THE UNIVERSITY OF
SYDNEY

13 August 2020

Re: University of Sydney- Engineering and Technology Precinct – Mod 1 (SSD - 8636_Mod_2)

SOUTHERN COURTYARD

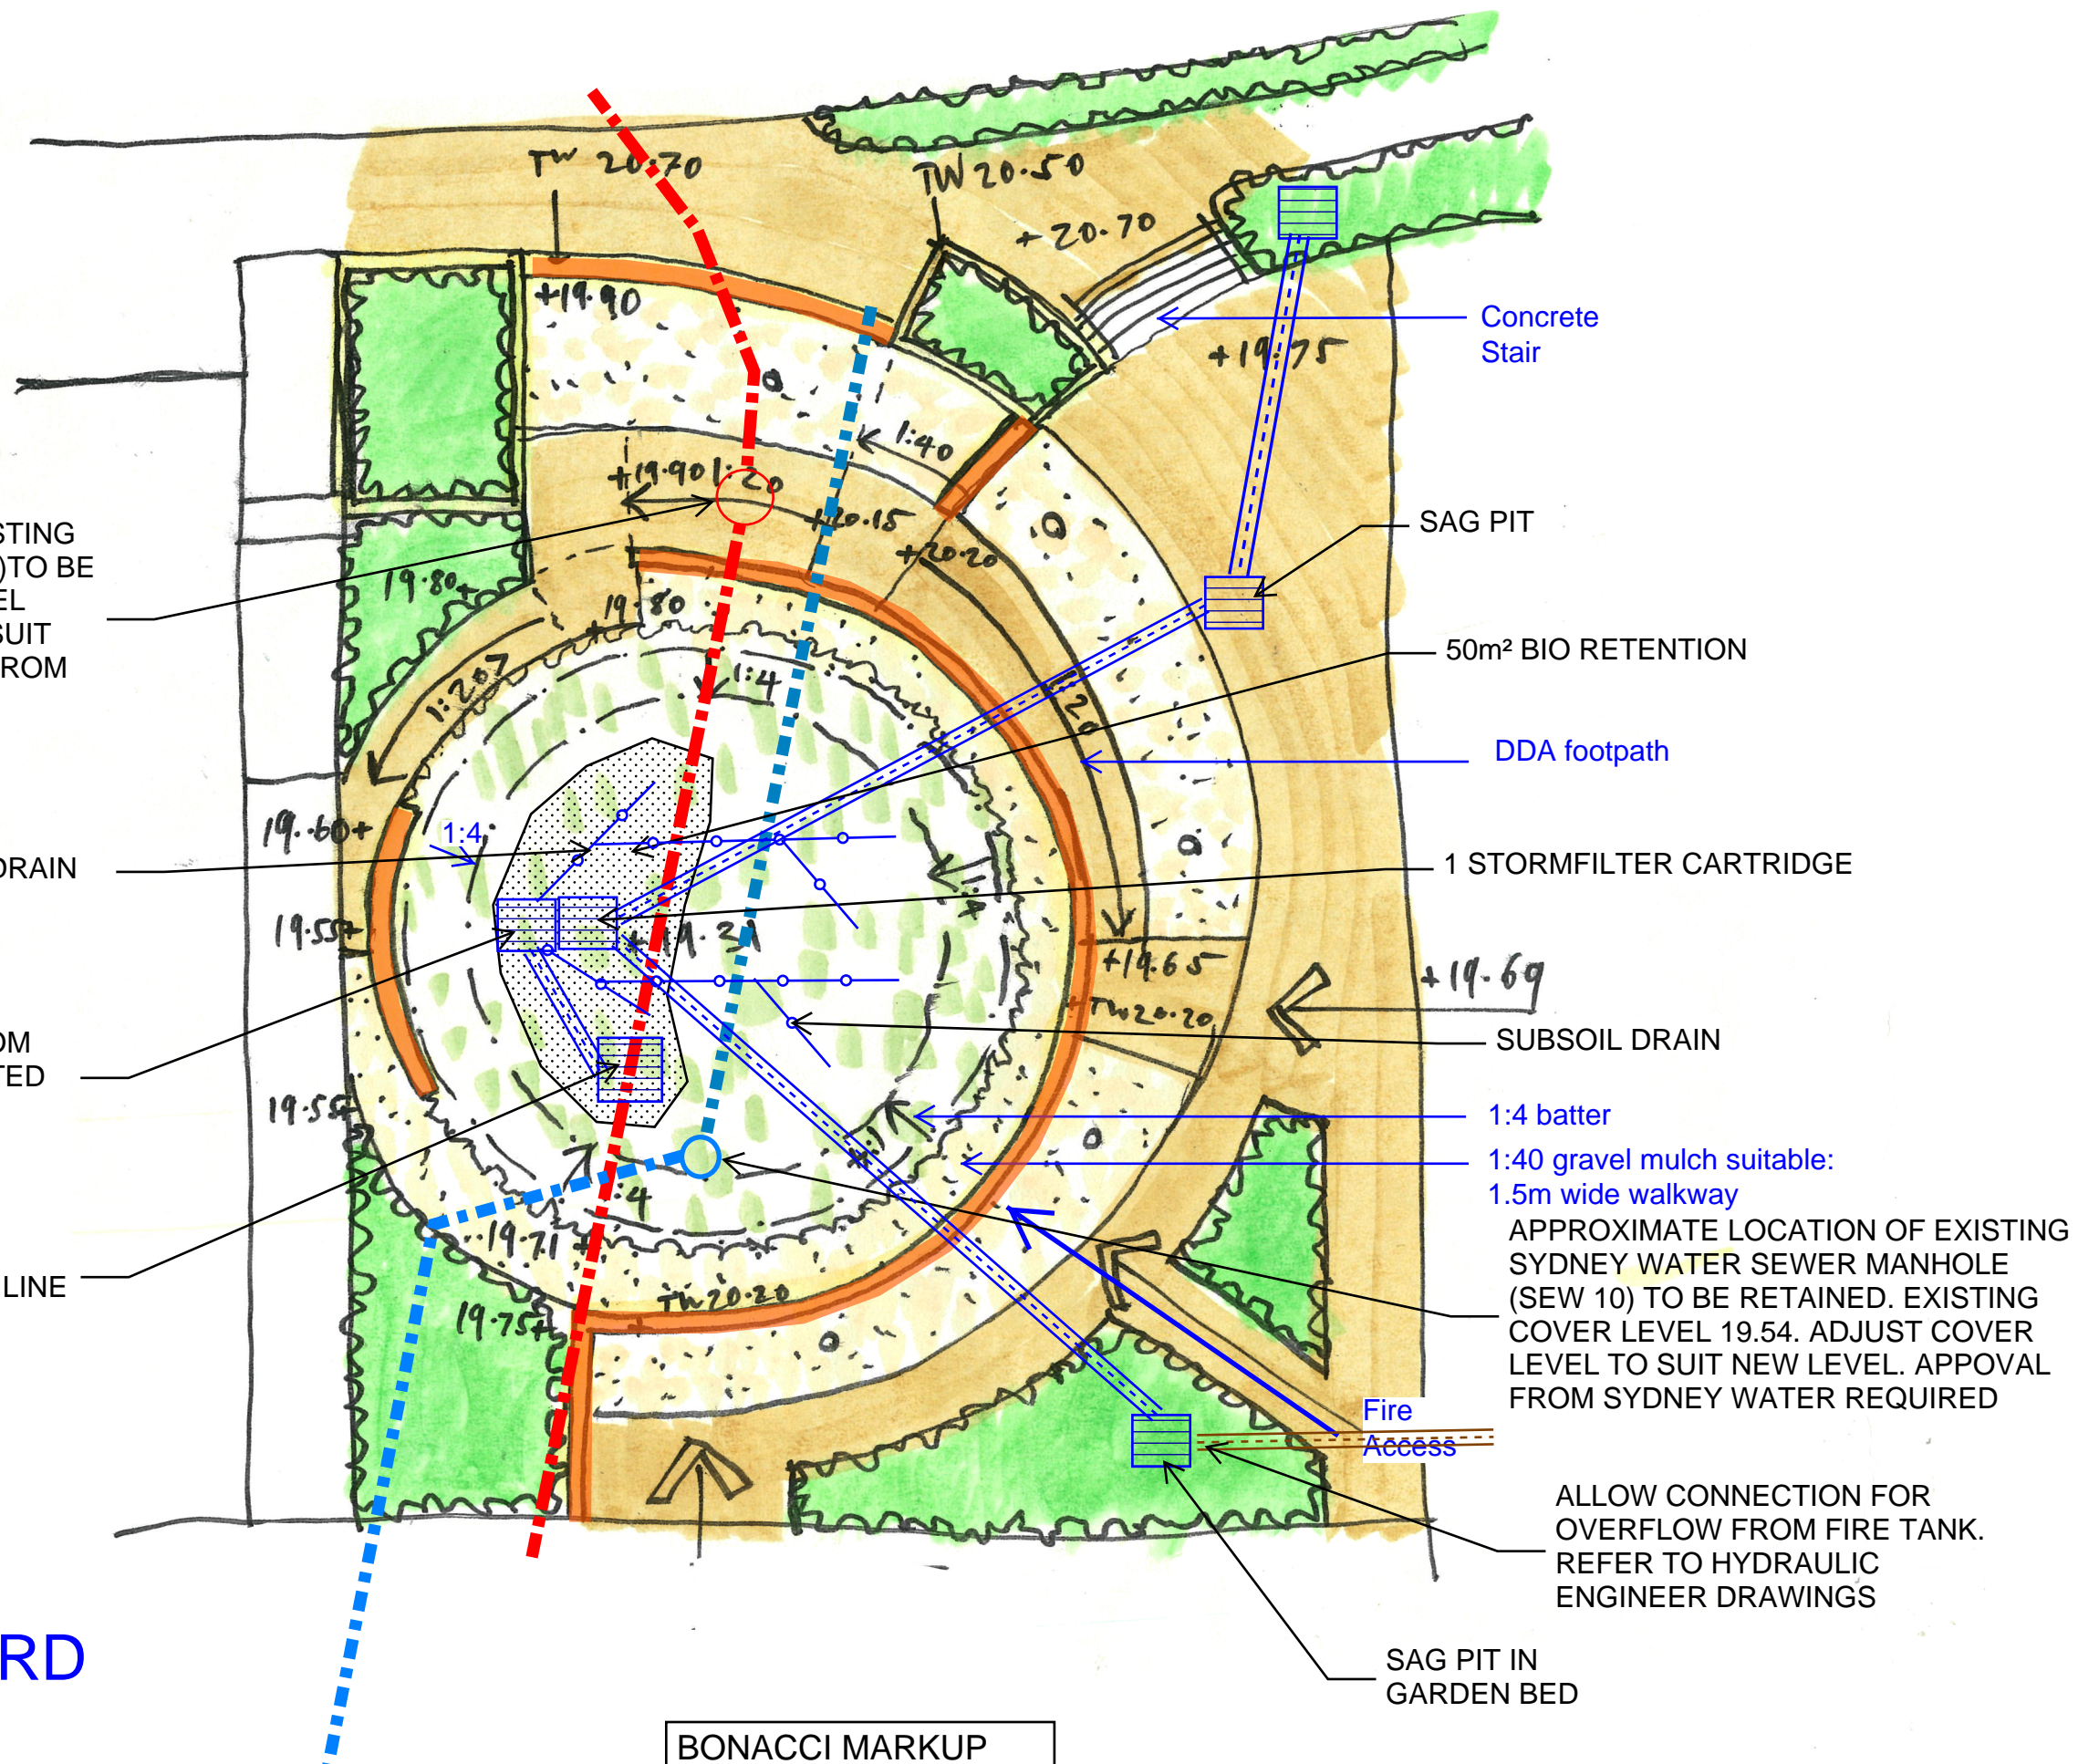
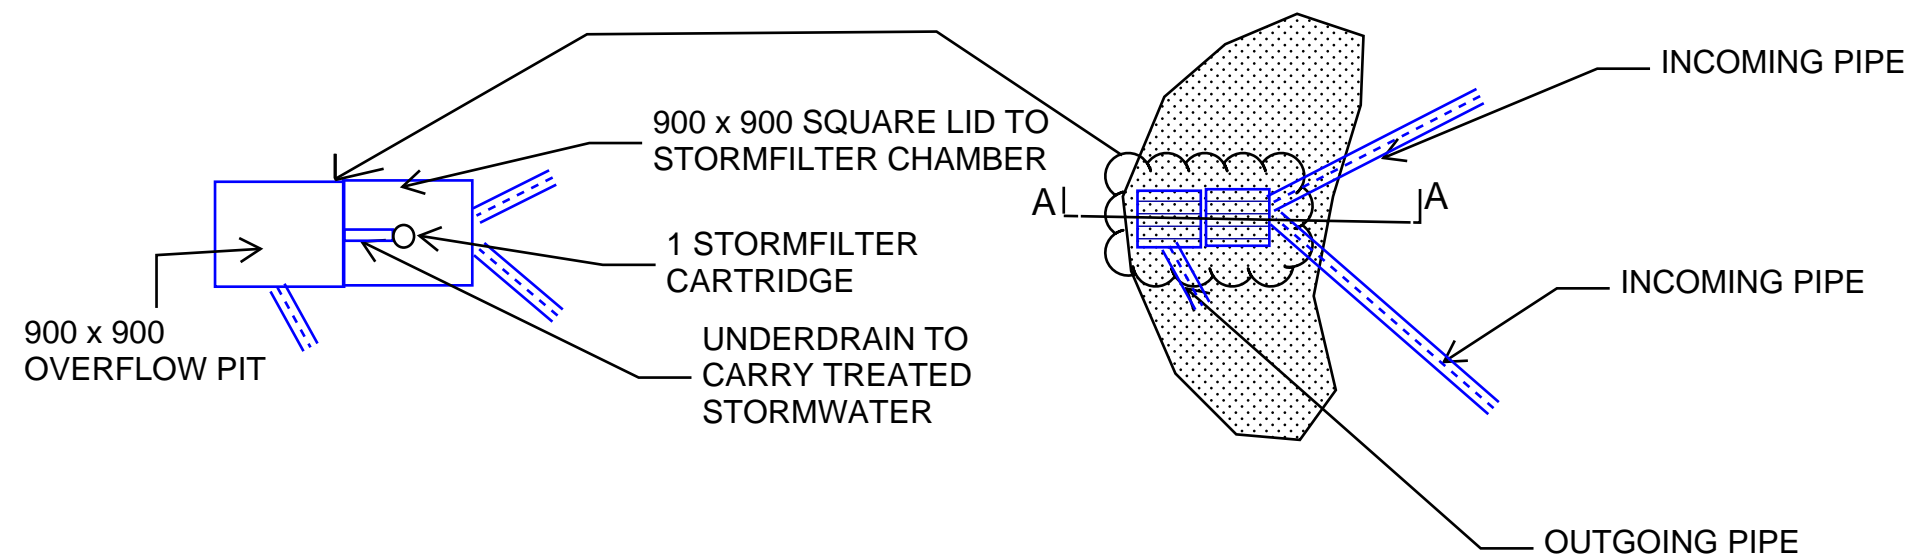
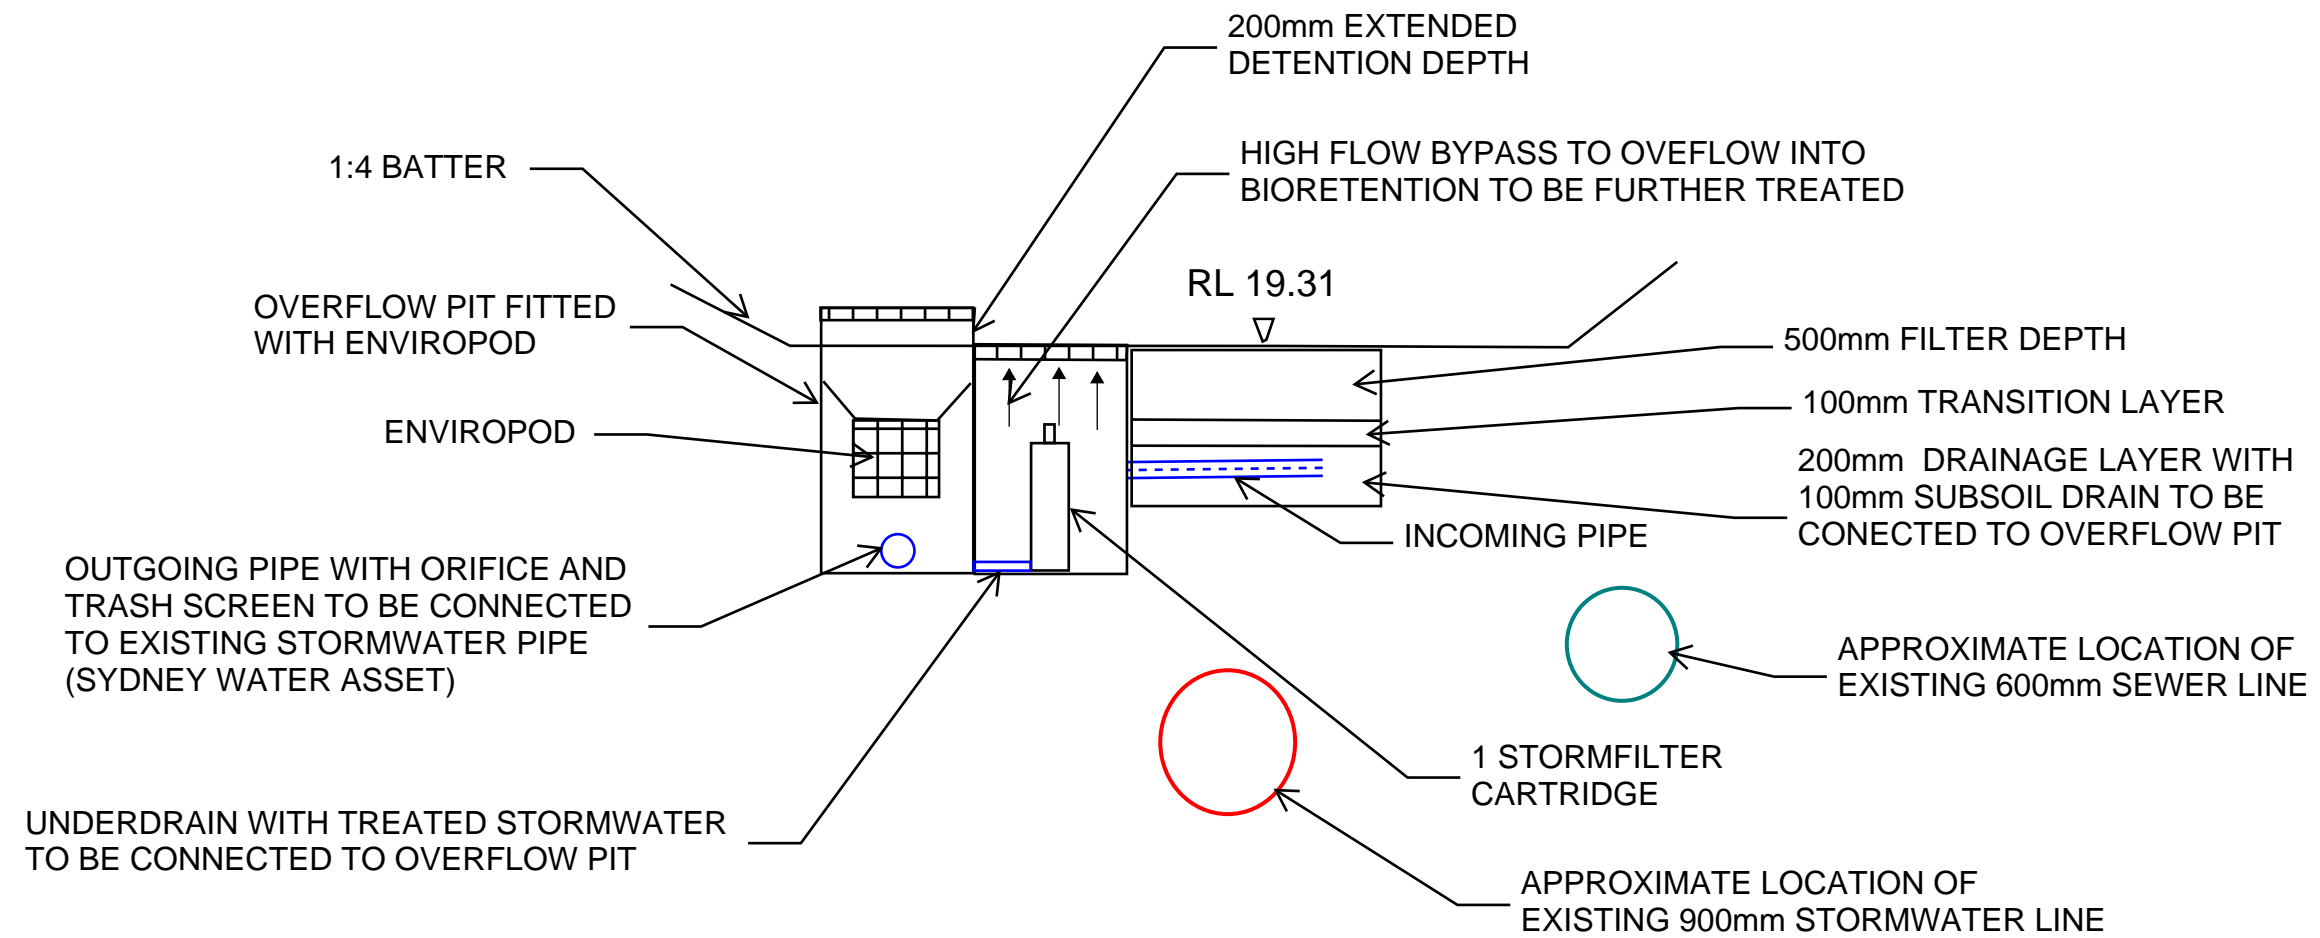
With regard to the 2nd point about water quality treatment, bio-retention is still proposed to treat the water quality of the overland flow. However, there are some alterations to the strategy sought to allow Basin D to be shallower in order to reduce the flood risk as detailed in Condition B38 below. Please refer to attachment 4 for details of the storm filter cartridge chamber of the proposed water quality treatment strategy for the stormwater collected from the building.

Regarding the first point for plans with sufficient levels and gradients, please refer to Attachment 3 for the revised plans of the basin. Note that the updated plans incorporate a seating wall which forms a 'wall around Basin D' as the engineering means to protect the building from a 1% AEP flood event. This wall provides the benefit of additionally separating pedestrians and pavement users from the basin. The
